From: Rael, Rudy E.
Sent: Monday, December 05, 2016 10:02 AM
To: 'Fred Arfman (freda@iacivil.com)'; 'bryanb@IACIVIL.COM'
Cc: Biazar, Shahab; Carrillo, Abiel X.
Subject: Eastside Renovation of Kennel D Canine Facilities

Project Title: Eastside Renovation of Kennel D Canine Facilities Building Permit #: _____ City Drainage #: K20D063

Based upon the information provided in your resubmittal received 5/9/16, the above referenced Grading and Drainage Report and plan cannot be approved for Building Permit until the following comments are addressed:

EASTSIDE ANIMAL SERVICES CENTER (COA FILE K20-D15).
ENGINEER'S CERTIFICATION FOR CERTIFICATE OF
OCCUPANCY APPROVAL FOR PARKING LOT THIS AREA
SUBMITTED SEPARATELY. ENGINEER'S STAMP DATED
SEPTEMBER 21, 1999 APPROVED PER LETTER DATED
OCTOBER 6, 1999.

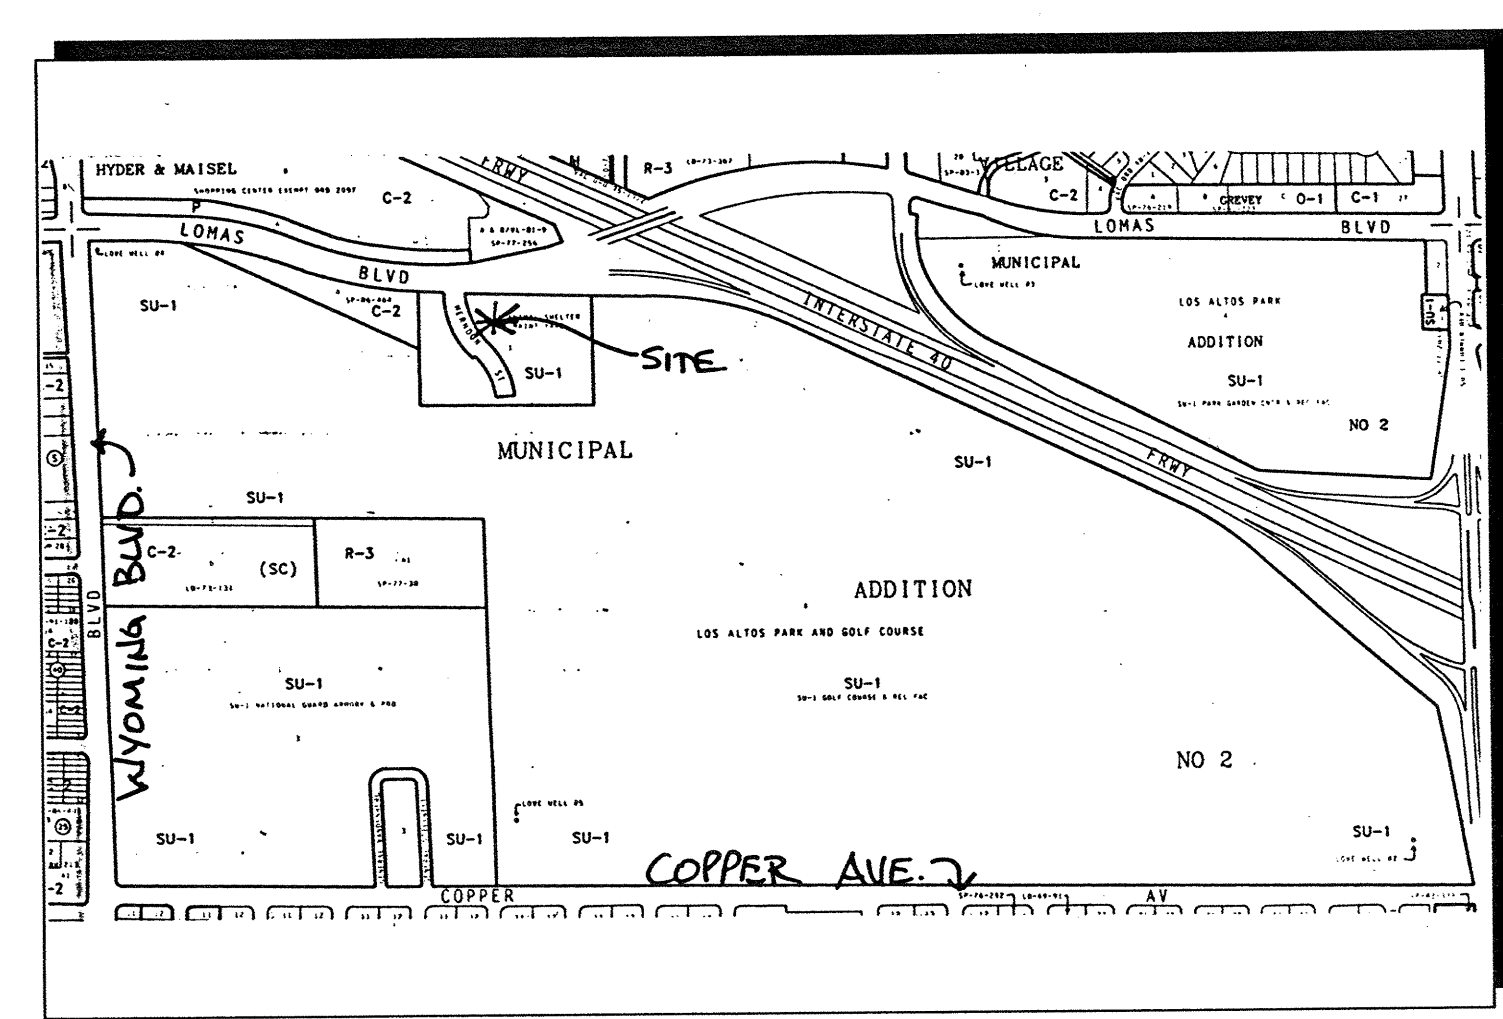
- Provide a CLOMR-F before beginning construction and follow with a LOMR-F. This will negate the need for a scour wall.
- Provide compensatory volume for the displacement of the AO zone. The first flush pond can be used for this application.
- A SO-19 is not required.
- Provide a build note stating that Waterproofing of the stem wall 2 feet above the BFE is required, along with the applicable certification from the company used for this application.

1. According to the latest FIRM, the smaller building just north of the parking area will be in Zone AO (1' Depth, see below). The finished floor will need to be set *at least* 1' above the highest adjacent grade to the building.

2. Overlay (approximately) the limits of the SFHA on the plan.
3. Processing a Floodplain Permit will be made a condition of Building Permit approval.
4. Stamp and date the revised plan.
